SITE DEVELOPMENT PLAN
CIMARRON-NORTHWEST INDUSTRIAL FILING NO. 4
 A REPLAT OF A PORTION OF LOT 1, BLOCK 2 CIMARRON-NORTHEAST INDUSTRIAL NORTHWEST
 LOCATED IN SECTION 6, TOWNSHIP 14 SOUTH, RANGE 65 WEST OF THE 6TH P.M.
 EL PASO COUNTY, COLORADO
 LOT 1 SCHLAUFMAN SUBDIVISION NO. 1., PLAT 12717

PCD FILE NO.: PPR1832

SITE DEVELOPMENT PLAN CIMARRON-NORTHWEST INDUSTRIAL FILING NO. 4

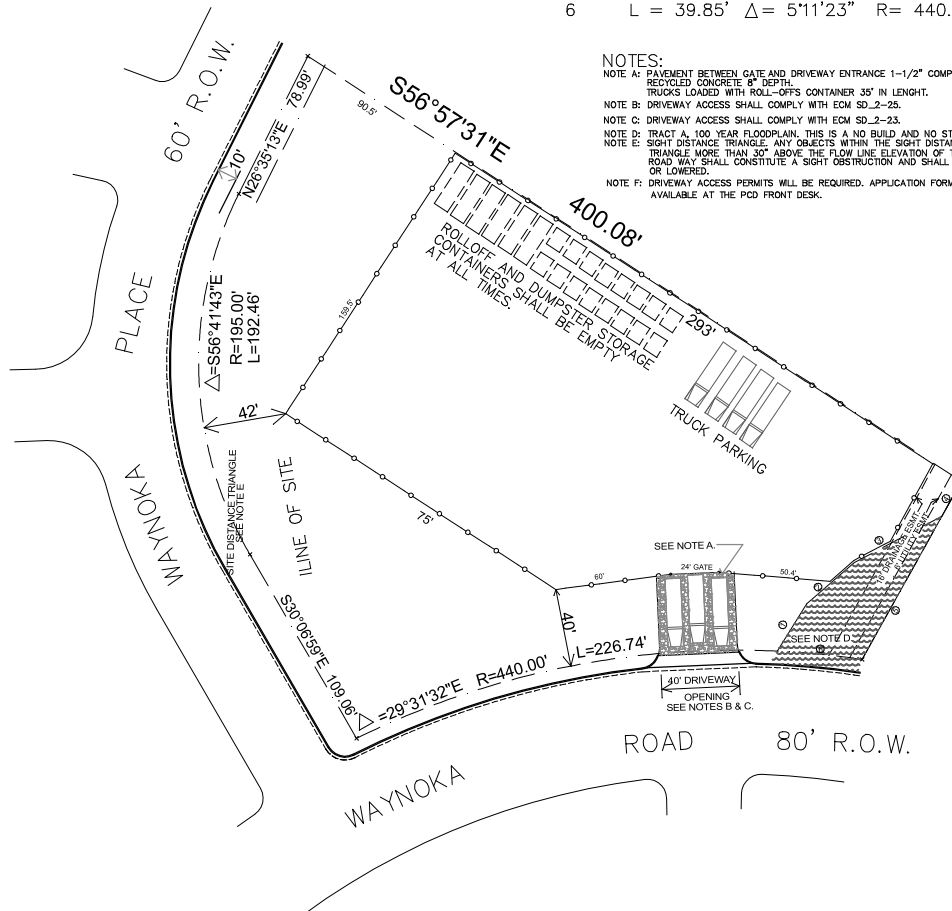
Revise the bearings and distances information for the property lines to match the recorded plat.

Include details SD 2-25 and SD2-23 on the site plan. **Unresolved**
 dsdgrimm
 11/13/2018 8:48:49 AM

If access is no longer being taken here then the site distance line does not need to be shown.

Indicate that "tract A" is not part of your property or this application.
